DEVELOPMENT REVIEW BOARD TRANSPORTATION DEVELOPMENT Standard Comment Sheet

DRB-1001922

**16. Project #1001922
Application # 02DRB-00667
Irving Land Partners**

**PLAT OF
TRACTS B-1A AND B-1B
IRVING LAND PARTNERS**

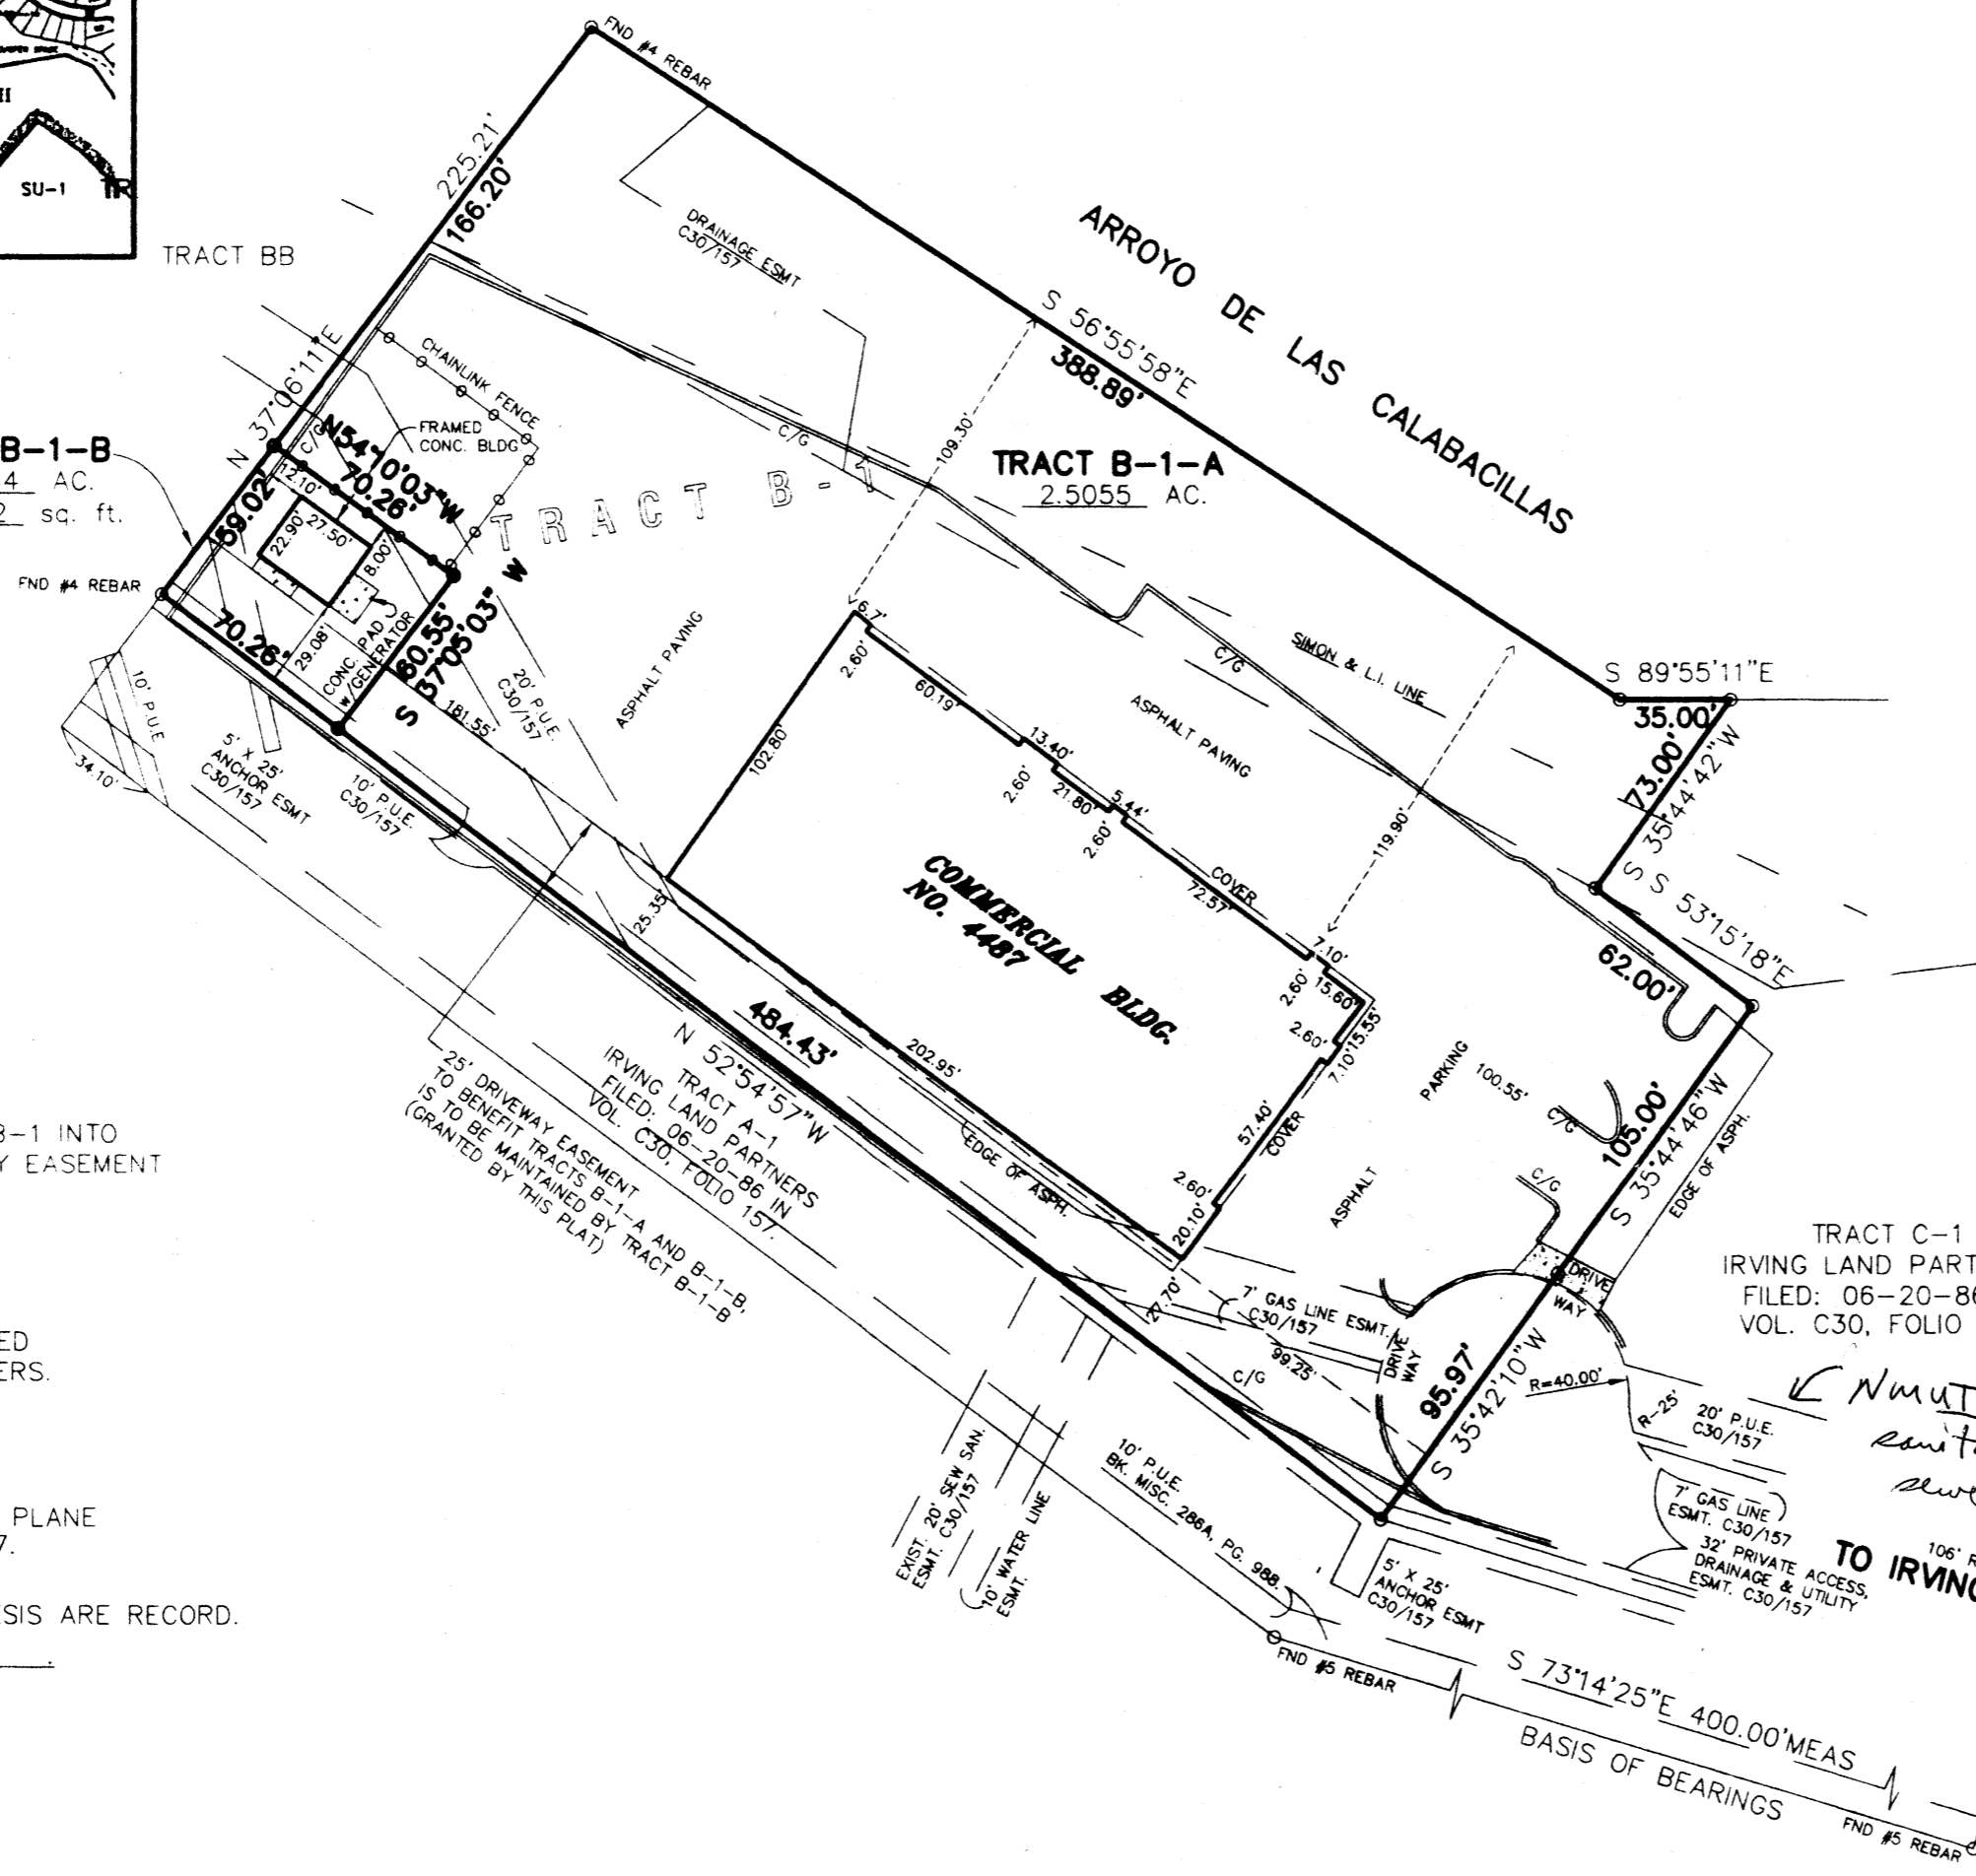
No.	Comment
<input type="checkbox"/>	Access to this site needs to be verified, from public right-of-way to this site.

Need crosslot drainage easement.
AMAFCA requirements must be met prior to final plat.
